From: Lederer, Andy - Communities
Sent: 02 October 2020 10:16
To: Bob Neville
Subject: RE: 20/02152/F - 13 Blackwood Place Bodicote Banbury OX15 4BD

I am currently dealing with a planning application for a new dwelling in the garden 13 Blackwood Place Bodicote, our ref. 20/02152/F. Part of the proposals include the removal of a number of trees from the boundary of the site with the Oxford Road to facilitate the construction of the proposed new access for the dwelling. The trees are outside of the application's site boundary on highways land, which I am presuming means the trees are in the County's ownership. My colleague has suggested that I make contact with you to see if you wish to make any comment on the application. I have attached the submitted Arboricultural Impact Assessment for reference, and further details of the application if required can be found on our website [here](#), using the application reference.

DRAWING TITLE
Tree Retention & Removal Plan

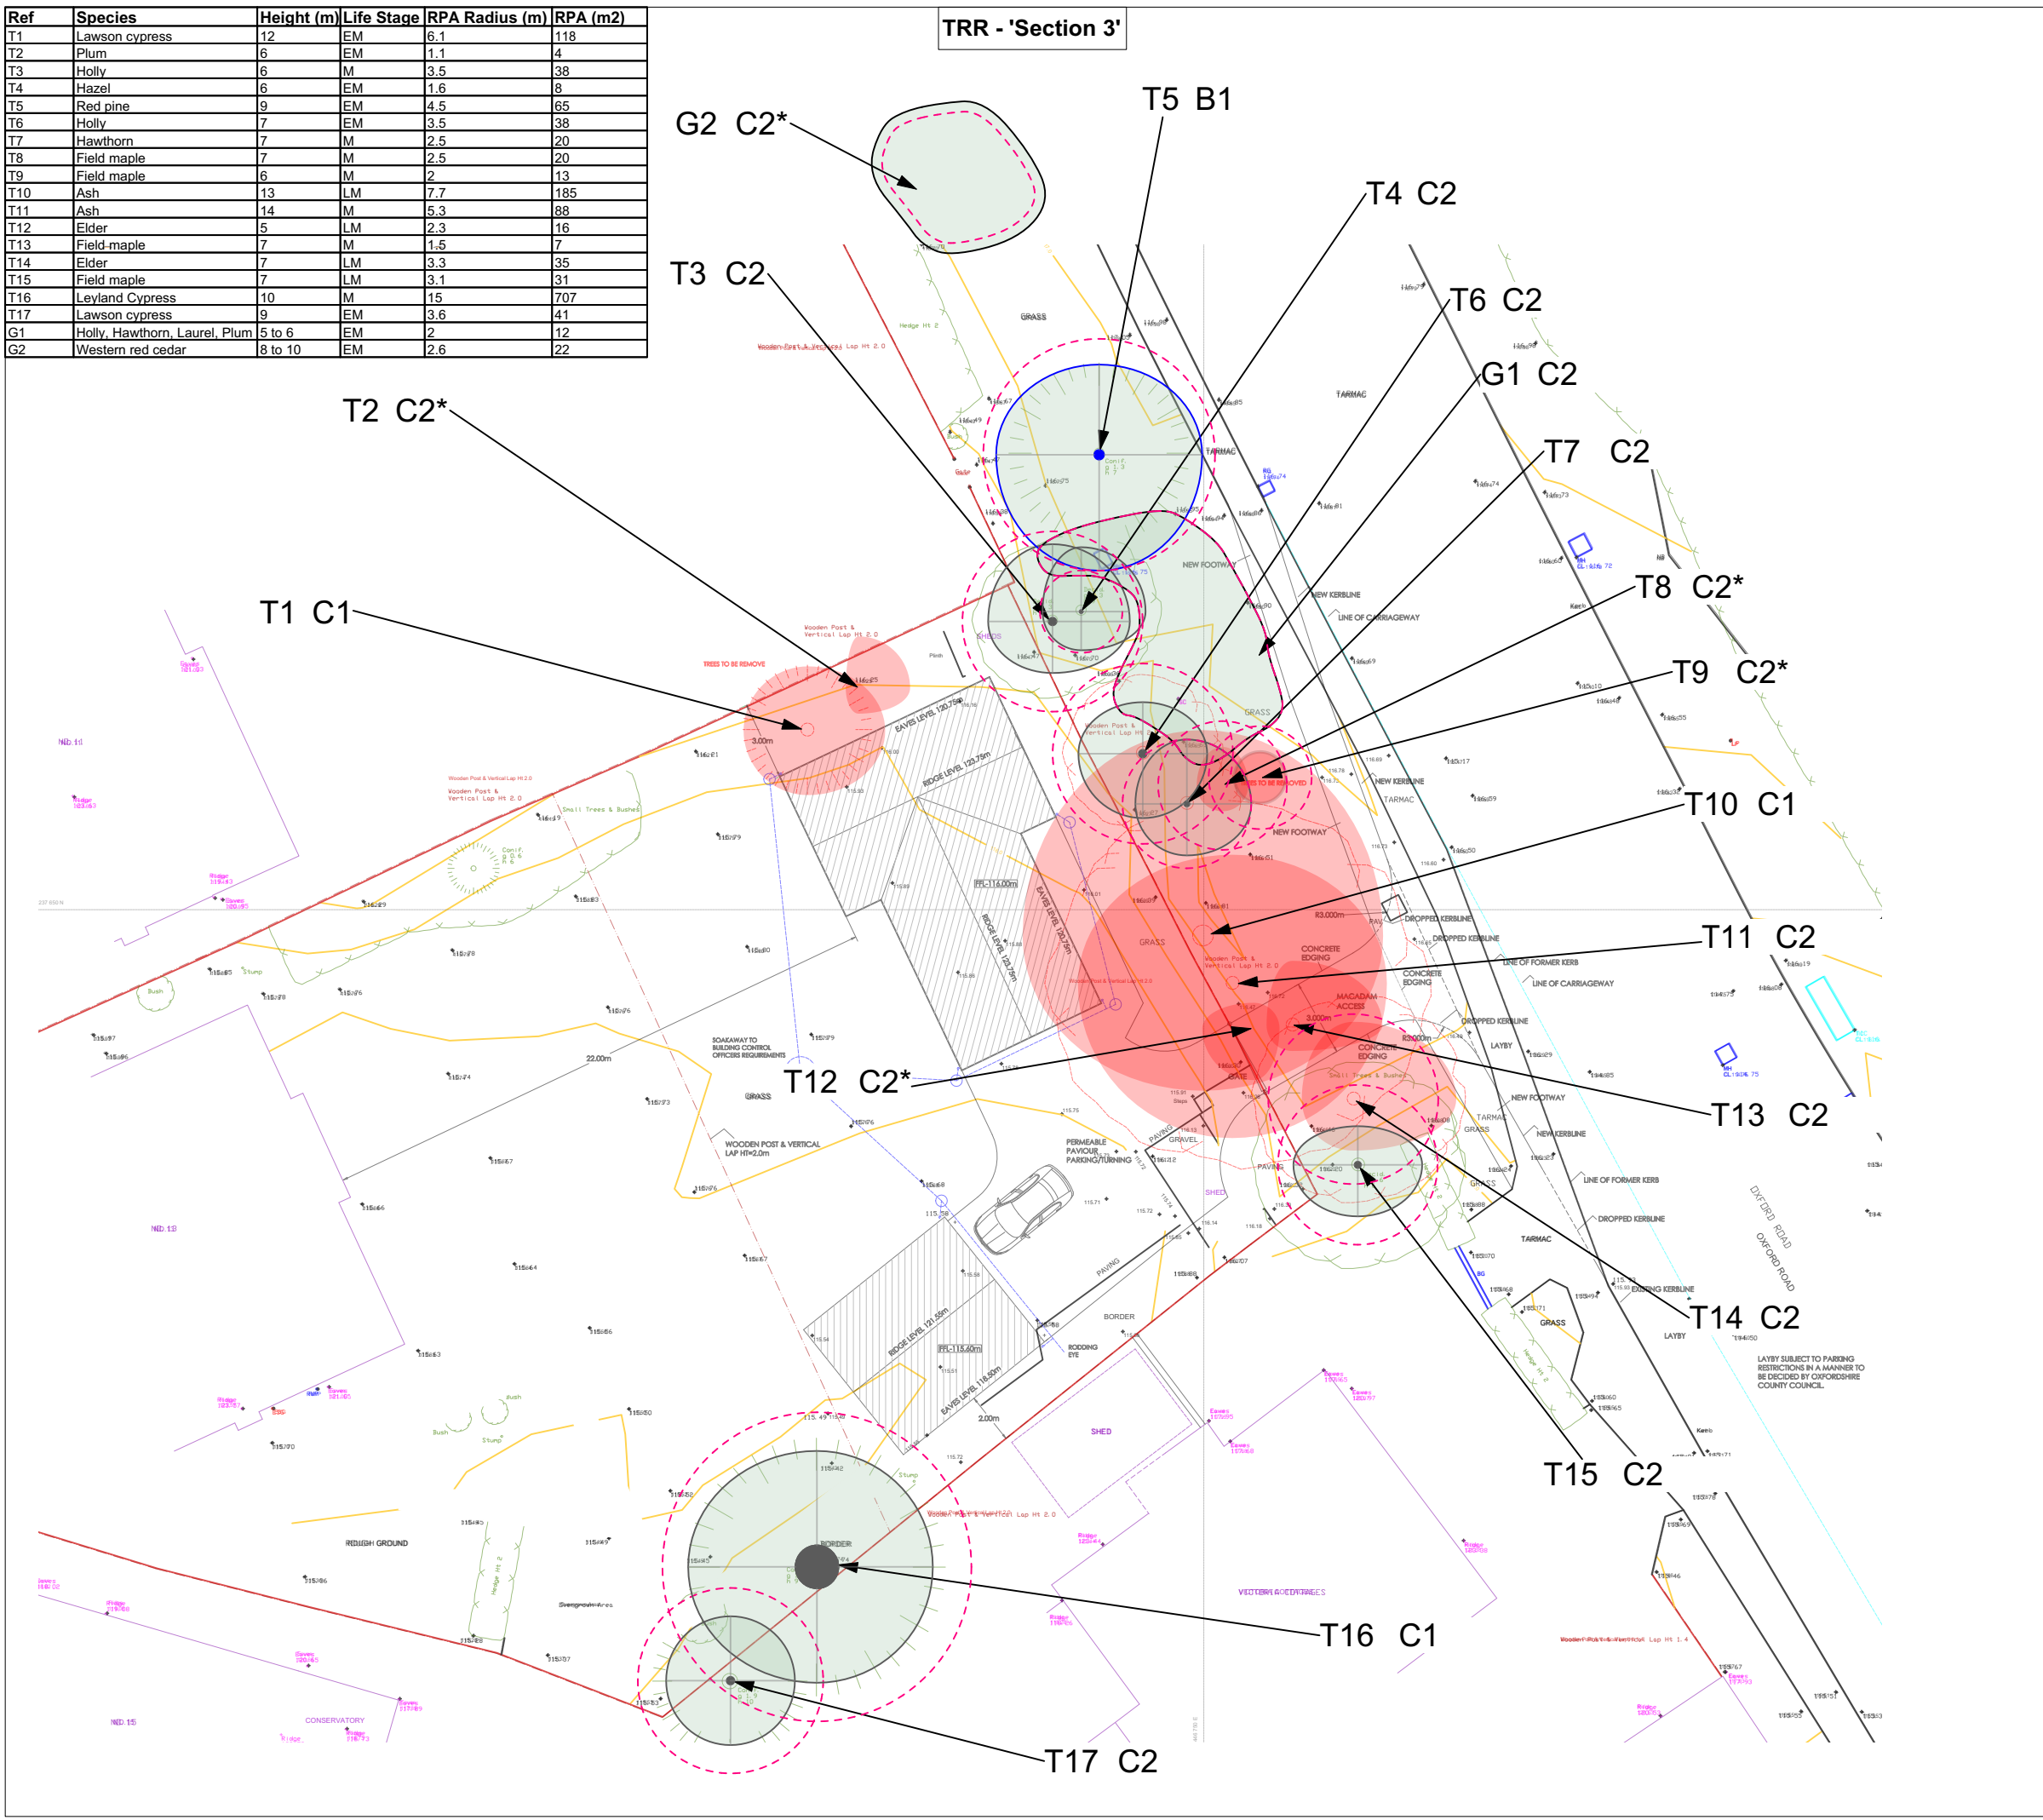
These trees provide a viable buffer from the main road and are currently a viable public asset.

I would not authorise their removal at this point.
